1 to 7 Picture House Apartments, George Street, Whalley, BB7 9TH

Planning Application Reference 3/2024/1016

Position Statement

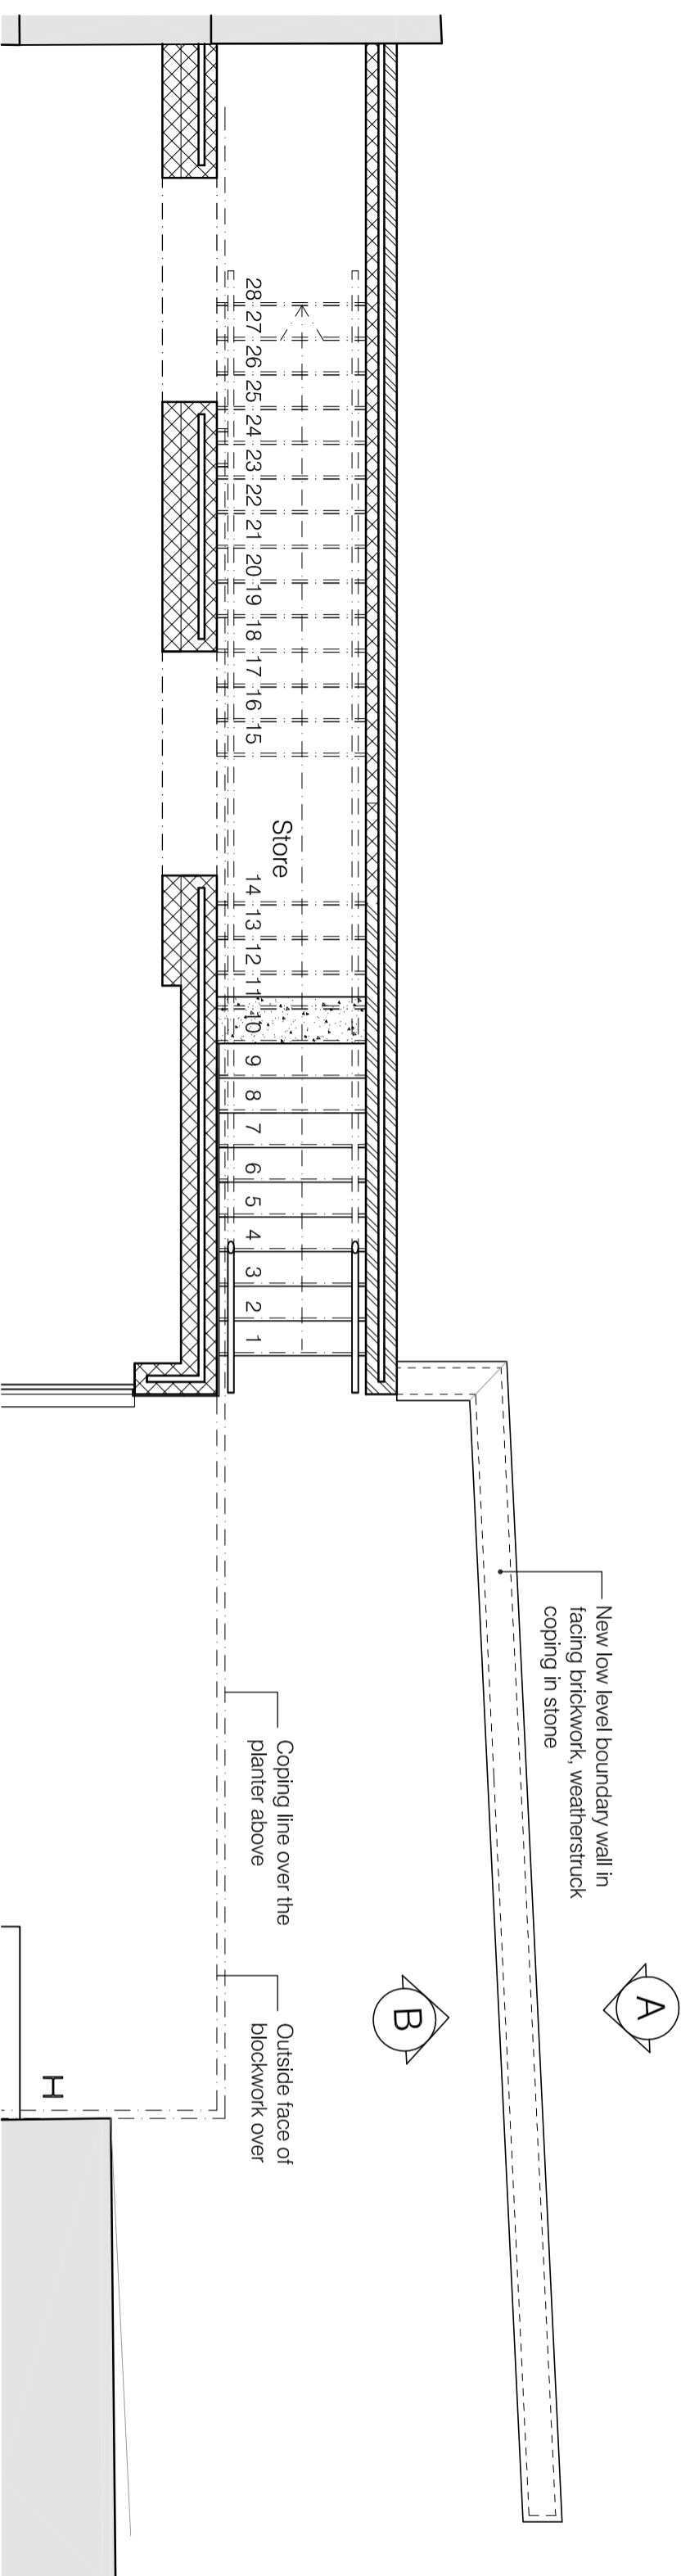
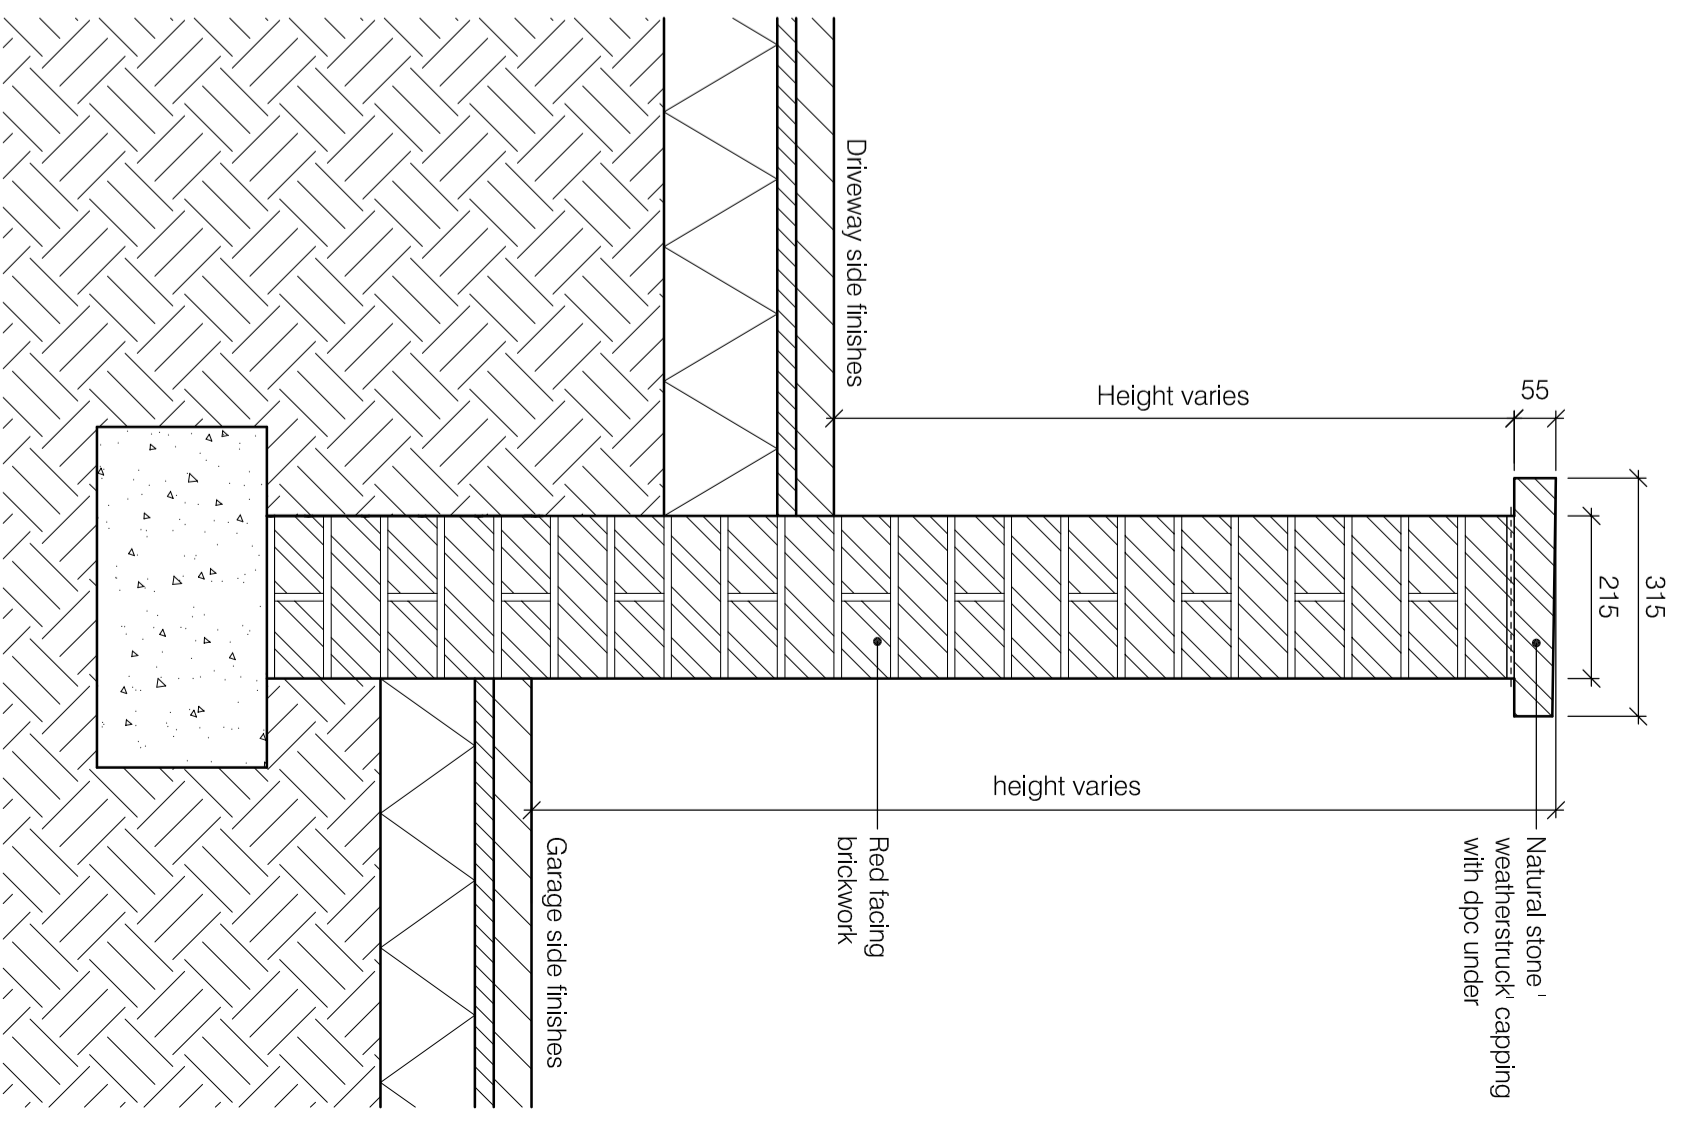
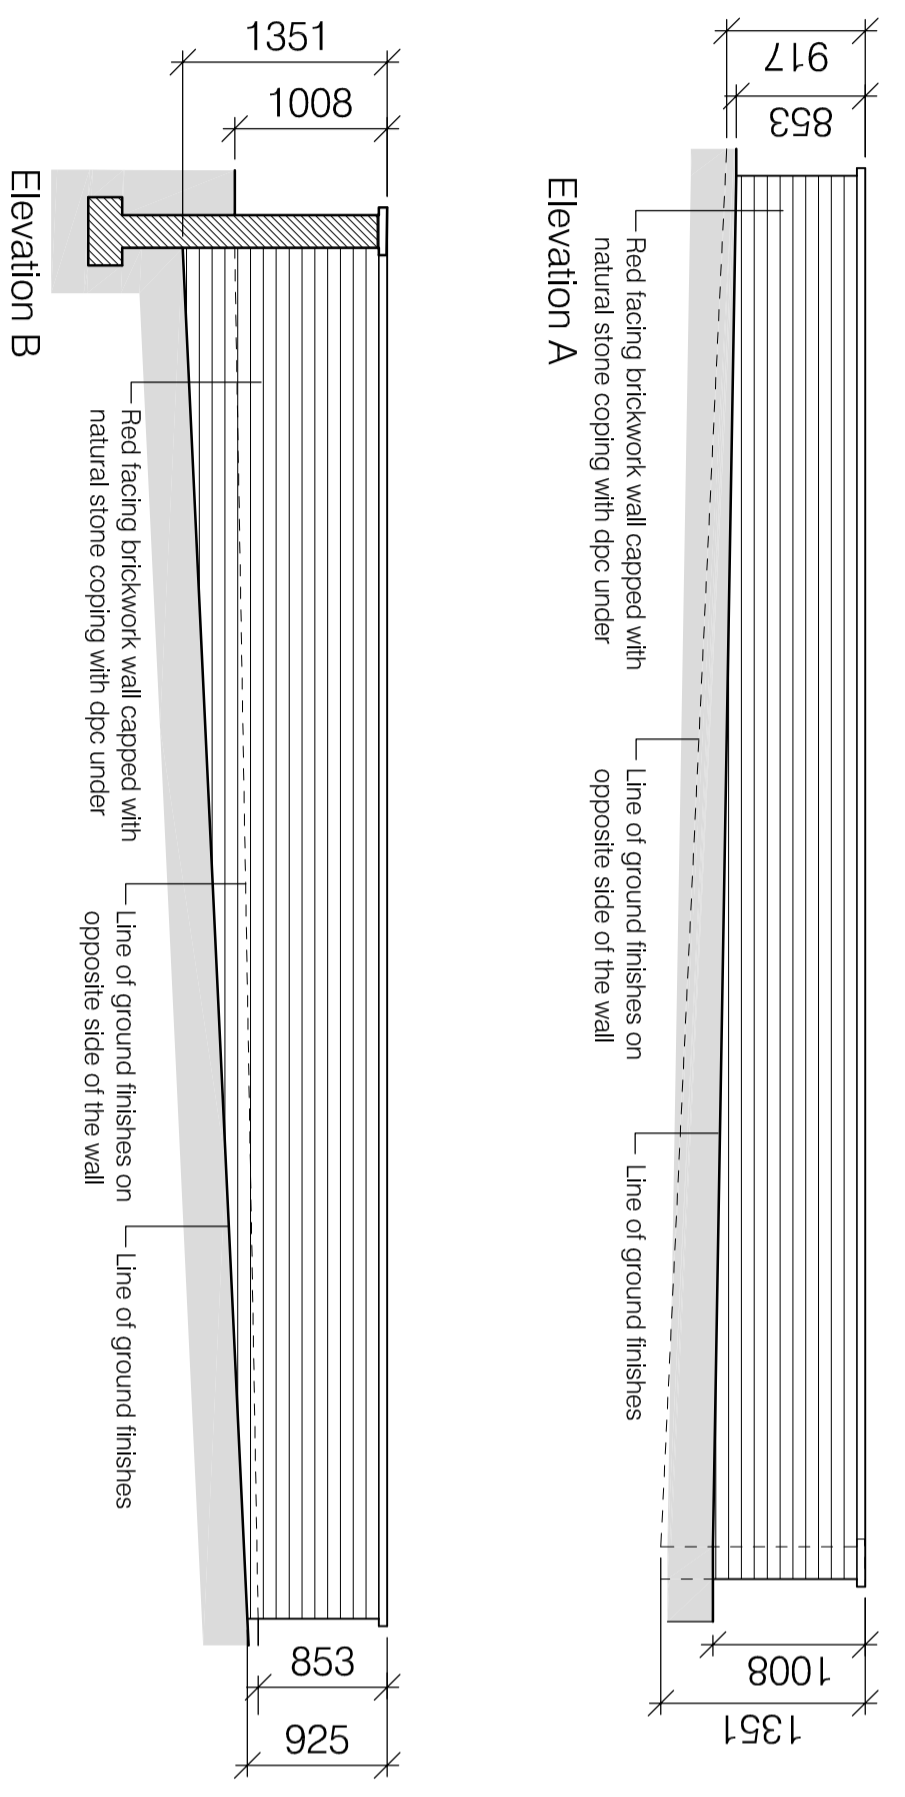
6.	Other Matters.	<ul style="list-style-type: none"> • Cycle Store repositioned. • Bin Store retained. • Roller Shutter Door retained. • EV Charging Points x 2. Revised Drawing: 2232-100 AB1. Retained rear boundary wall on original foundation. Revised Drawings: 2232-410cC; 2232-100 AB1. Superseded Drawings 2232-410 & 100	This will be retained inside the building as submitted to improve security and ease of access. Bin Store: RVBC confirmed no further information is required. Roller Shutter: RVBC confirmed no further information is required. EVCP: Expert/qualified advice received on limited grid-load capability. There is no development plan requirement for 1 EV Charging Point per dwelling. Rear wall: Wrongly described as re-positioned. New wall has been built on original foundations. More secure with better access.

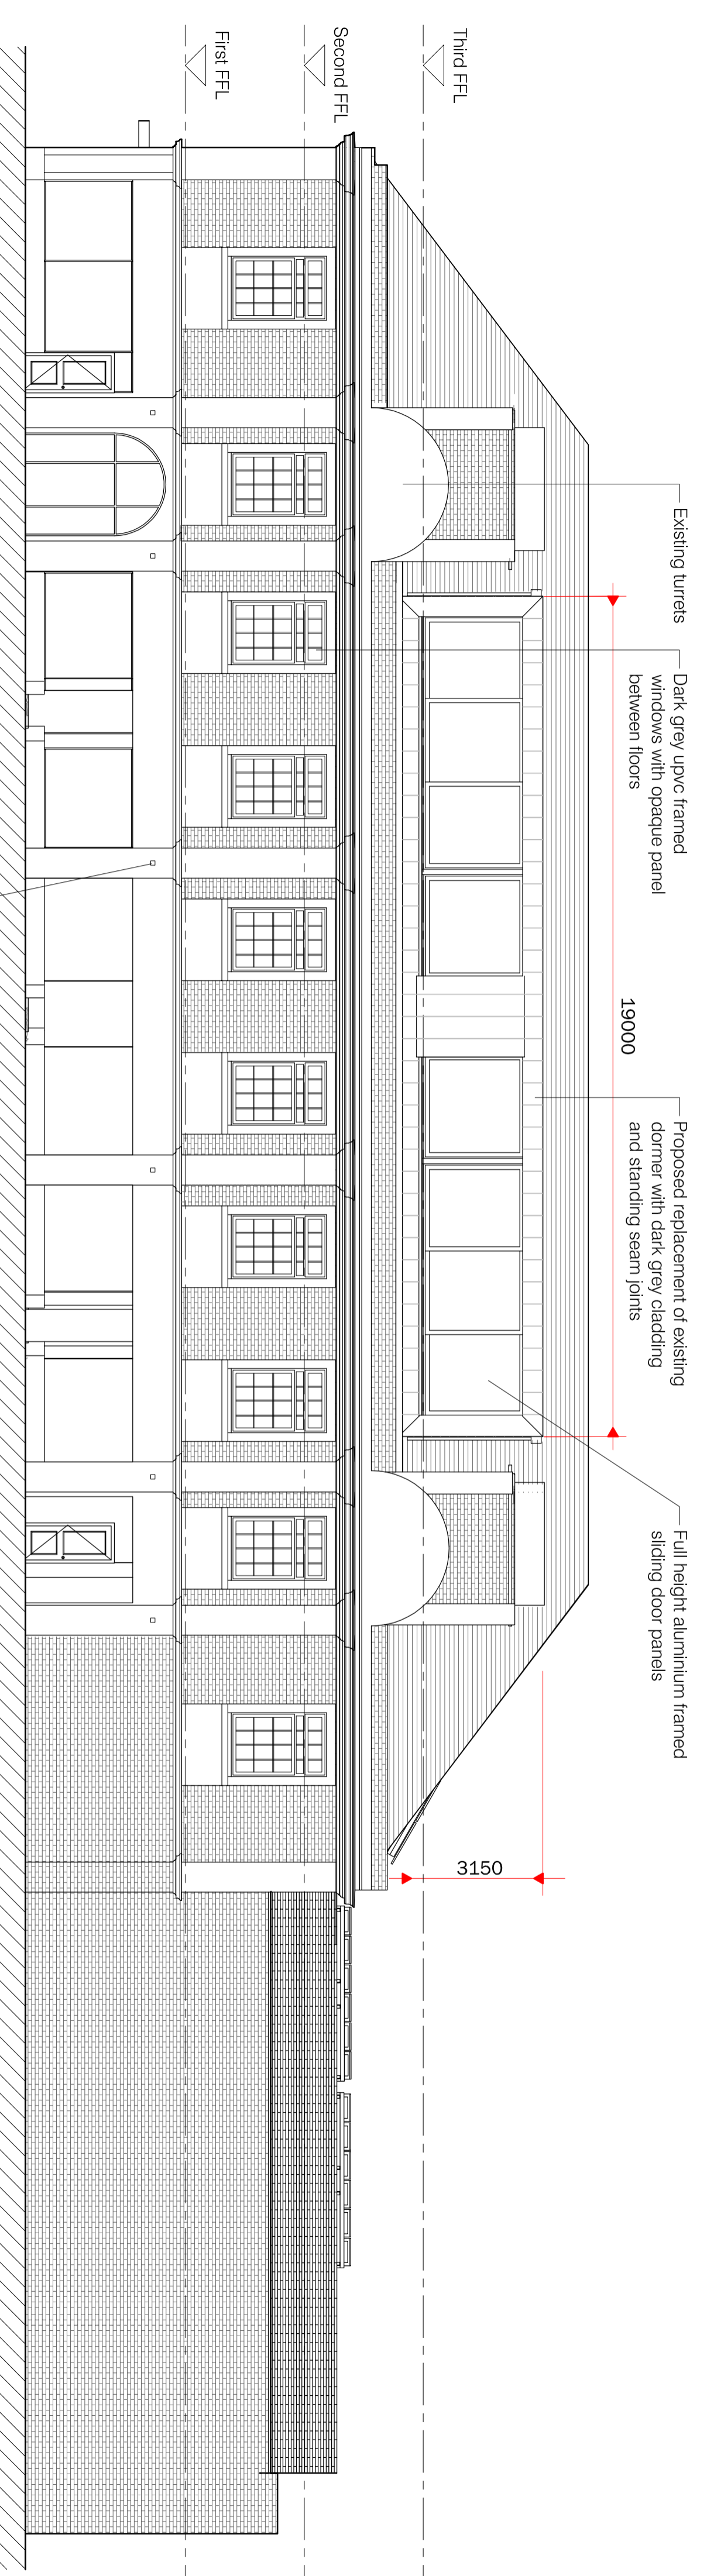
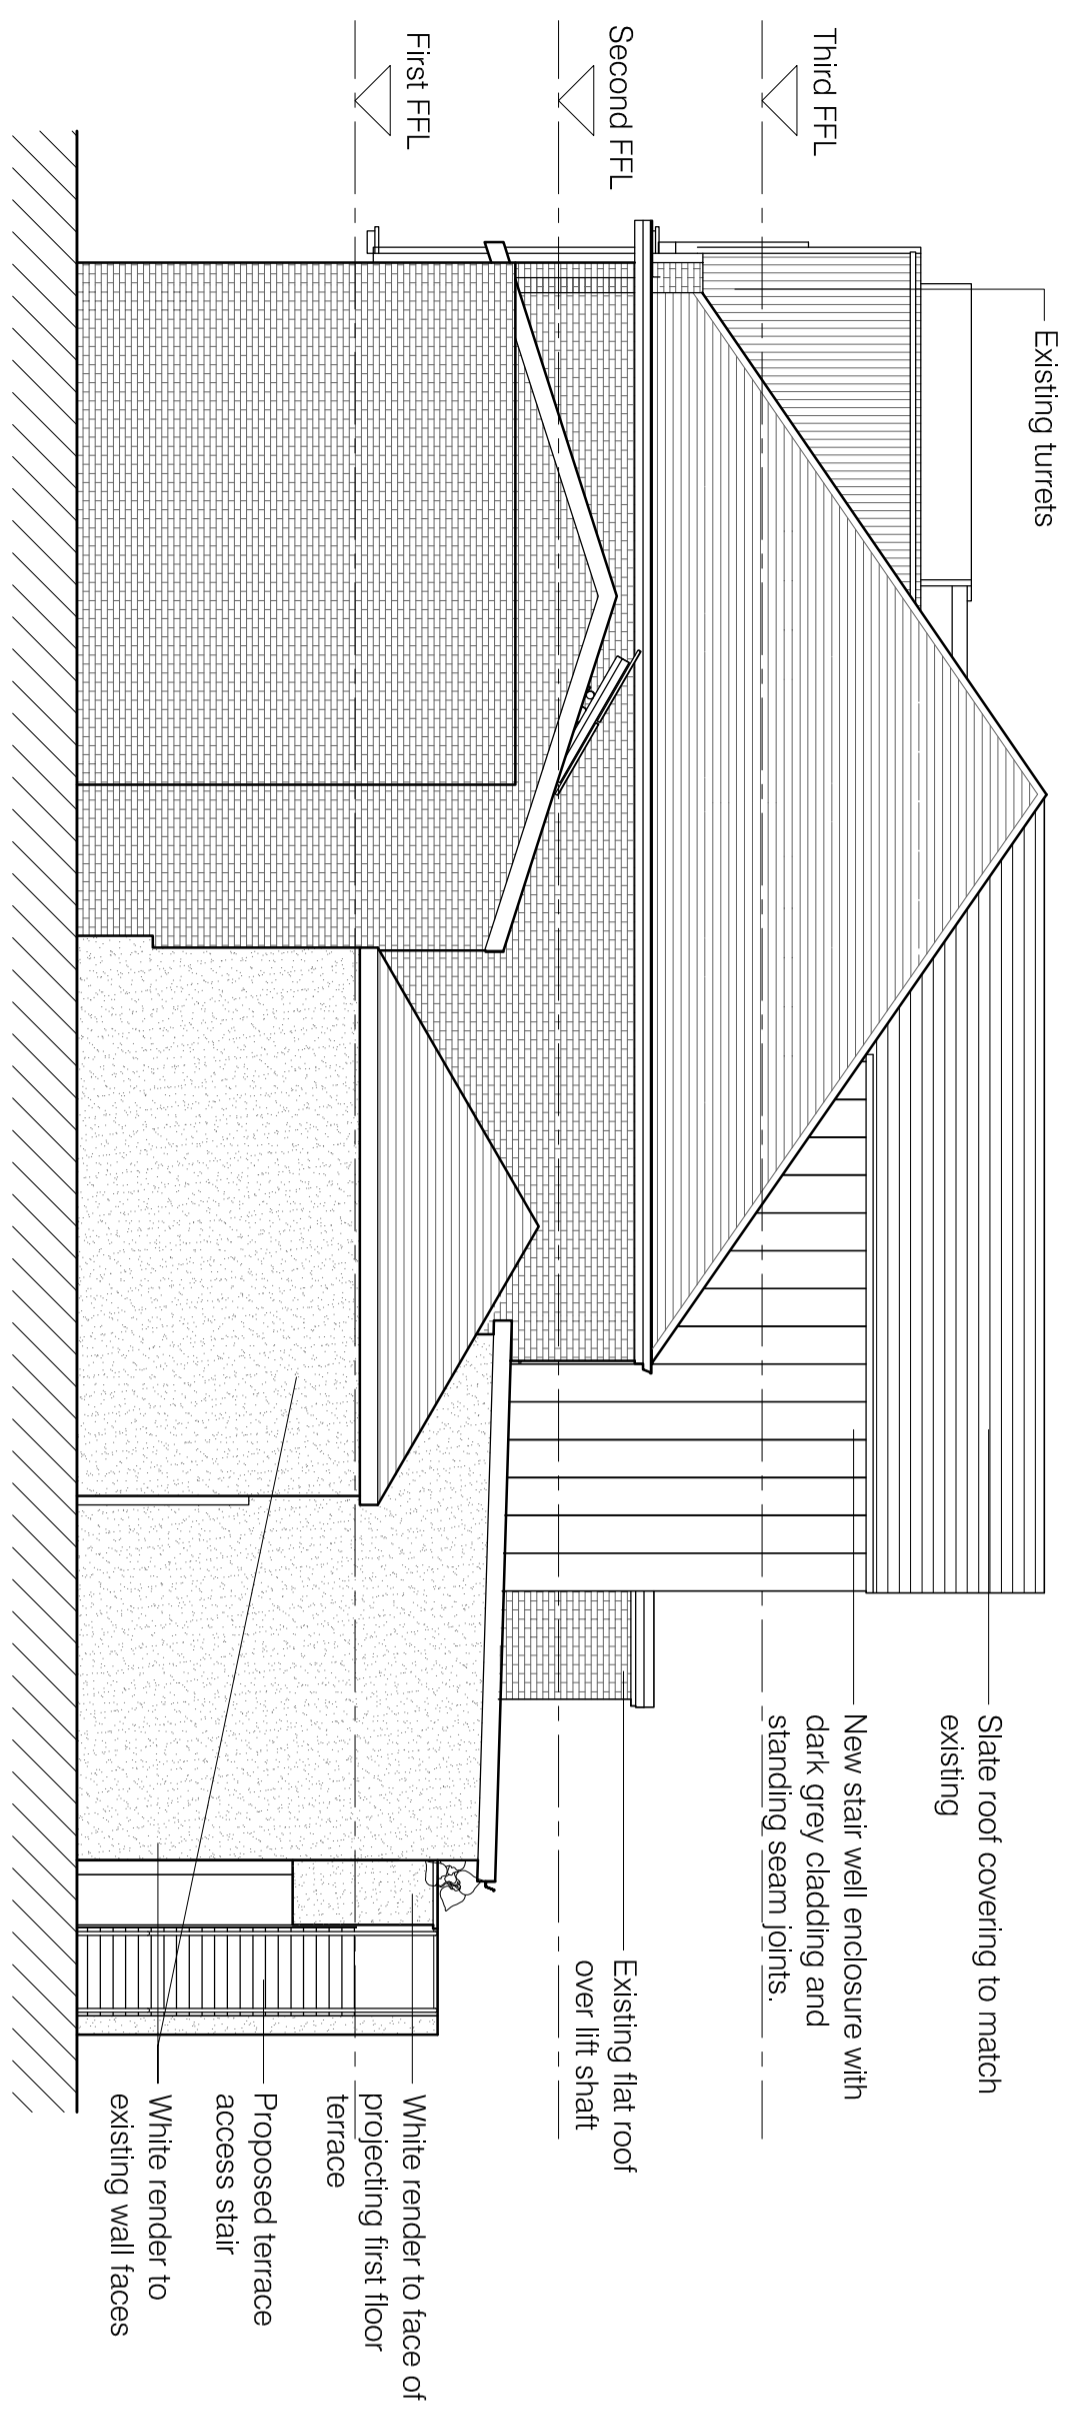
3.	Appropriateness of uPVC Window Replacements.	<p>uPVC to be retained as per drawings. Grey colour to match roof slates and complement black ground floor retail shops. Revised Drawing: 2232-300 AB1 (including existing colour specification RAL 7016 Anthracite Grey). Supersedes: 2232-300</p>	<p>Original uPVC windows fitted during 1986 retail showroom refurbishment undertaken by Ingham's Builders, Clitheroe. The windows (design and finish) are considered appropriate in this location/context. Choice of uPVC material was driven largely by technical advice to maximise thermal performance and in design terms screen the floor levels which cross these openings. The grey colour (RAL 7016 Anthracite Grey) matches the grey slate roof and complements the black ground floor units. Any replacement costly, disruptive and unnecessary for the existing residents and neighbours. Any change to the colour or finish is not considered necessary. However, if considered essential the applicant would accept appropriately worded conditions to this effect.</p>

4.	Front Dormer Cladding.	<p>Cladding to be retained. Grey colour as above considered appropriate. Revised Drawing: 2232-300 – AB1 (including existing colour specification RAL 7016 Anthracite Grey). Supersedes 2232-300</p>	<p>Choice of aluminium cladding material is based not only on appearance and finish. But also, on technical advice and fire safety. The design change was because of the need for fire resistant distance between the two apartments and enabled internal design to be approved. We consider there is limited difference visually or aesthetically.</p>
